**Re: McDonald's Old Town MRP, 2305 Central Ave,
Traffic Variance Option 1
Engineer's Stamp: Not Dated (J13-D053)**

Kristal D. Metro, P.E.
Traffic Engineer, Planning Dept.
Development Review Services

McDonald's Old Town MRP
Variance Option 1
Rec'd. 12/31/13

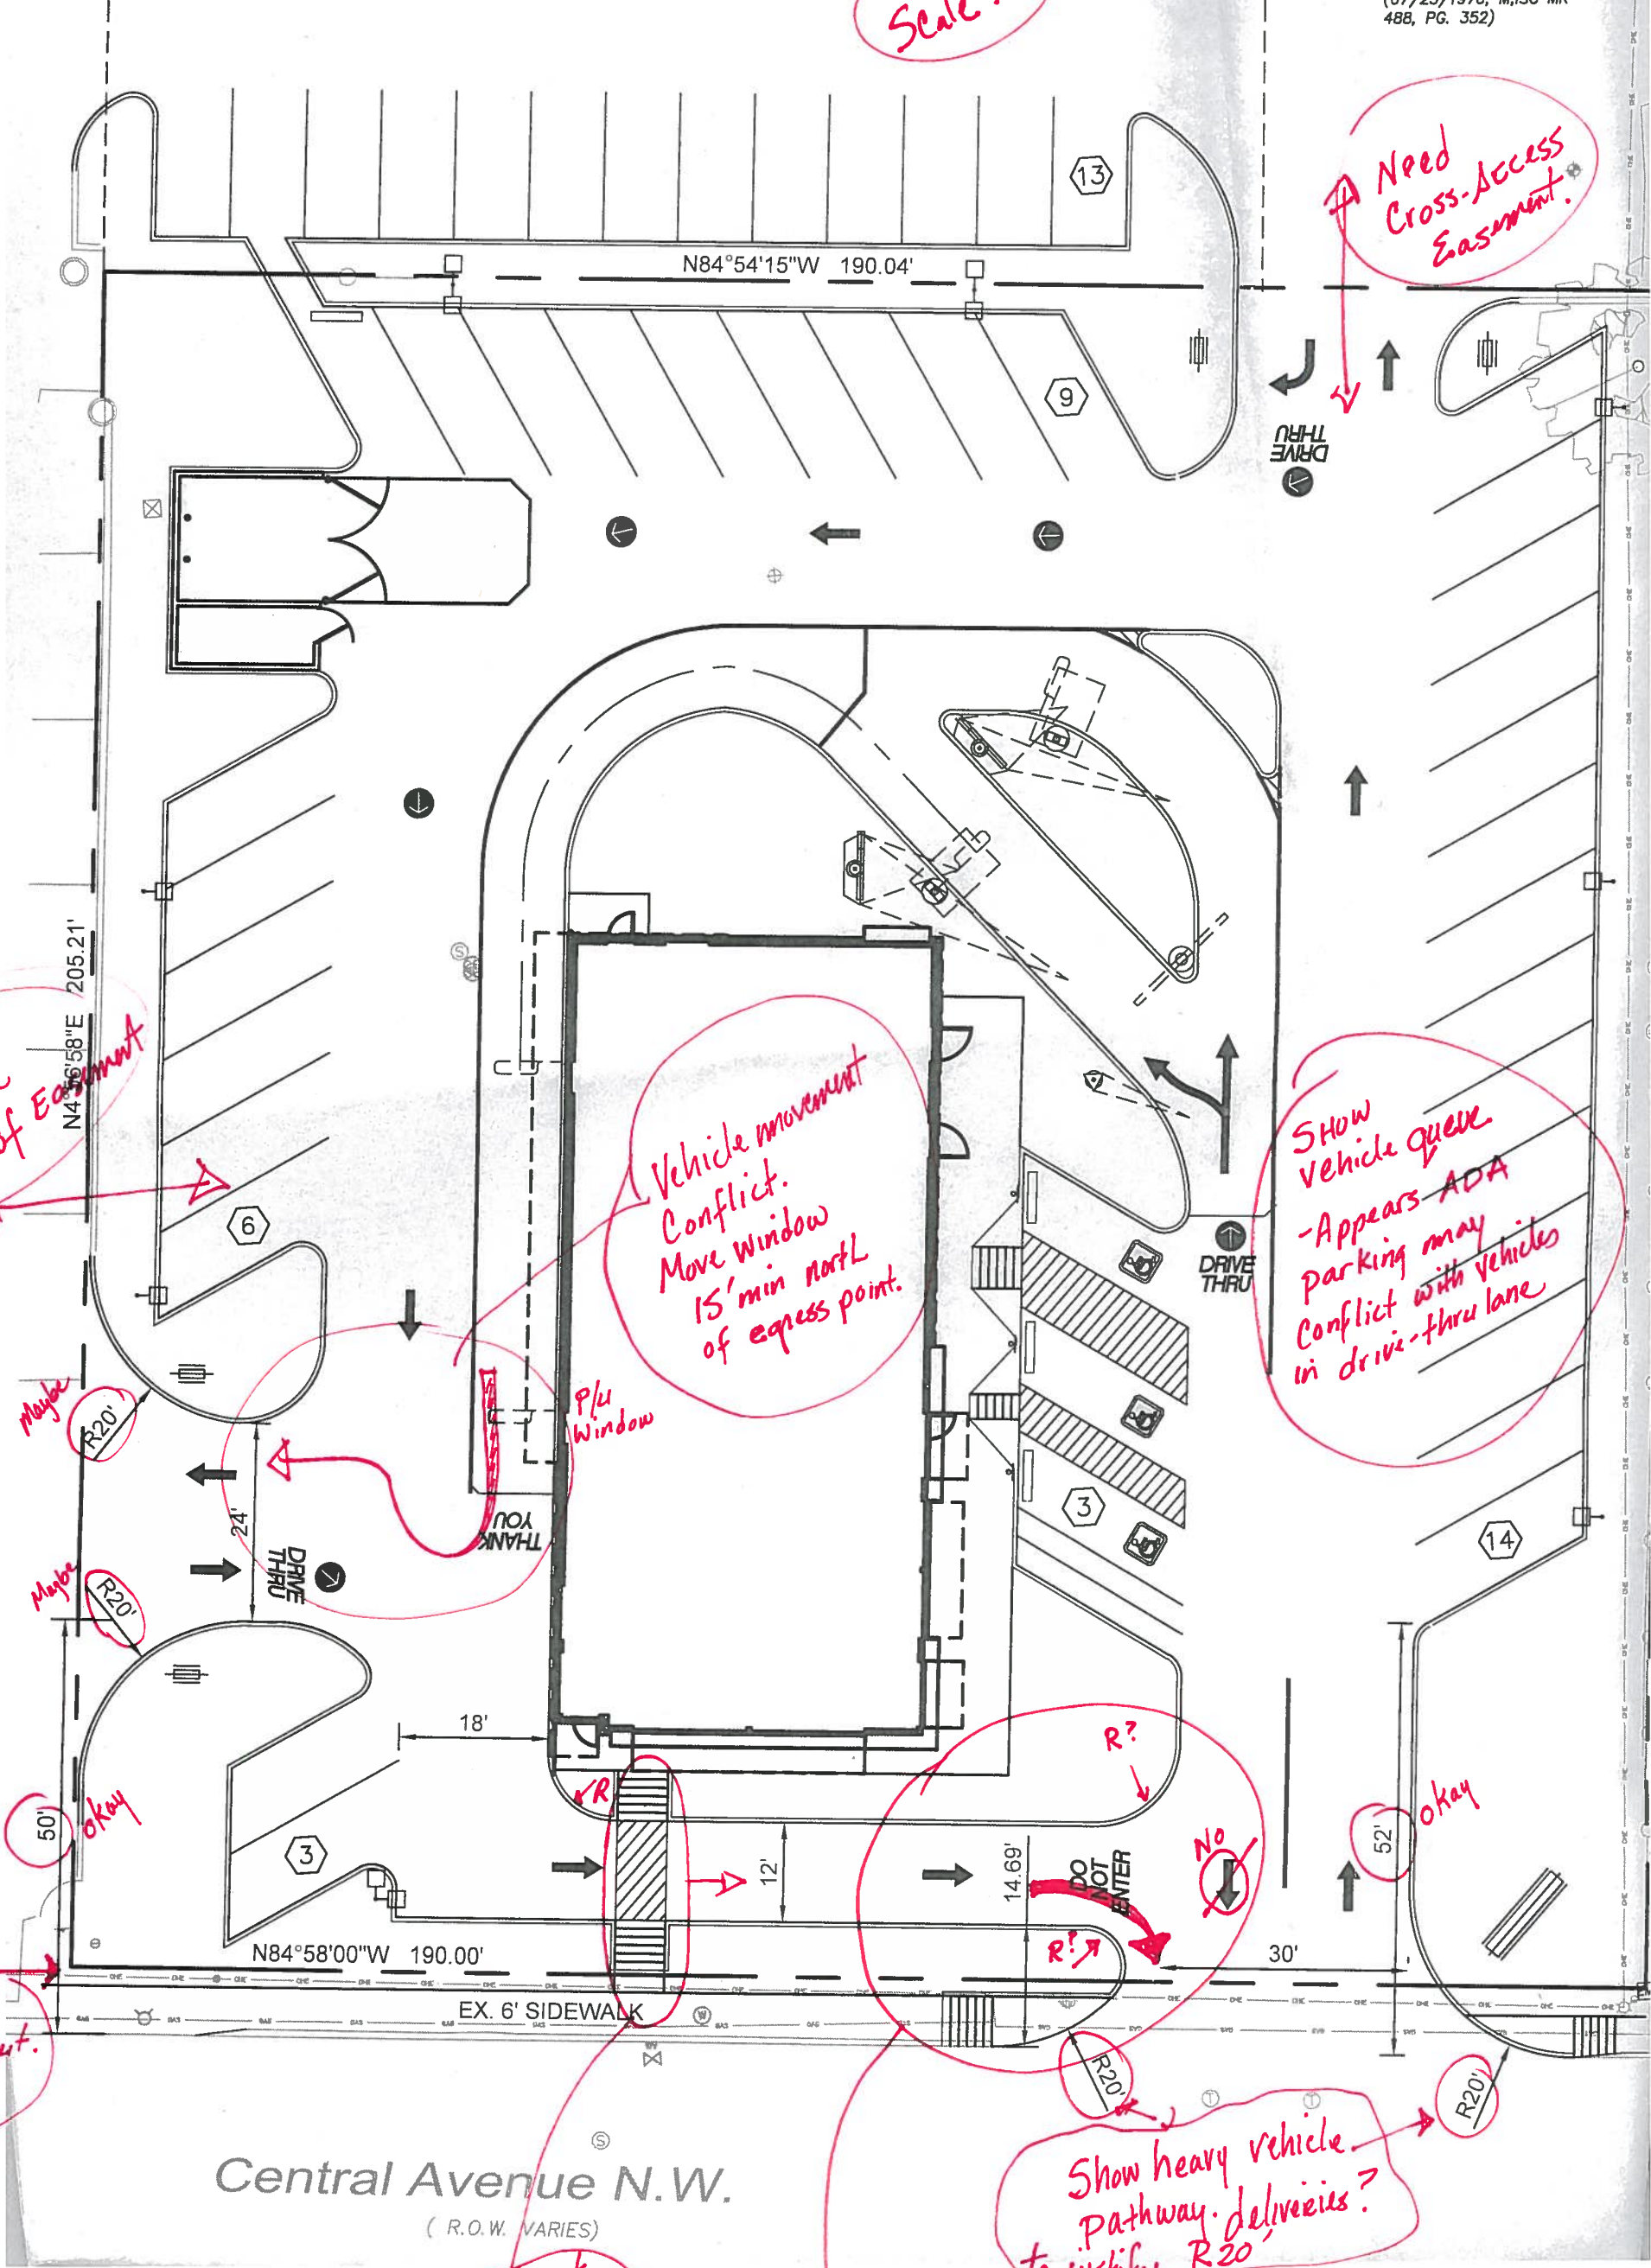
1. The submitted site plan must provide all details required in the DPM. Proposed infrastructure is integrated; therefore, a variance to one dimension must be viewed as part of a whole, complete submittal (lengths, widths, radii, references to COA standards, easements, scale, professional stamp, etc.)

2. Regarding the request for a variance to DPM throat depth - a reduced throat depth from 100 ft to no less than 50 ft would be acceptable per the design layout provided.

3. Regarding the request for reducing the curb radius at drives from required 25 ft to 20 ft requires justification. Please provide a vehicle template showing the heavy delivery vehicle pathway with proposed radii and drive aisle widths.

4. A red lined scan of Variance Option is provided in an attachment for clarification of additional concerns with TCL.
 - Show vehicle queue at drive-thru lane. It appears that ADA parking may conflict with vehicle approach to drive-thru lane.

- Provide copies of Cross-Access Easements to adjacent lots.
 - Suggest relocating pedestrian connection from COA sidewalk to building entrance.
 - Remove pavement arrow indicating two-directional movement at eastern drive.
5. All previously submitted comments from TCL letter 12/8/13 must be addressed.
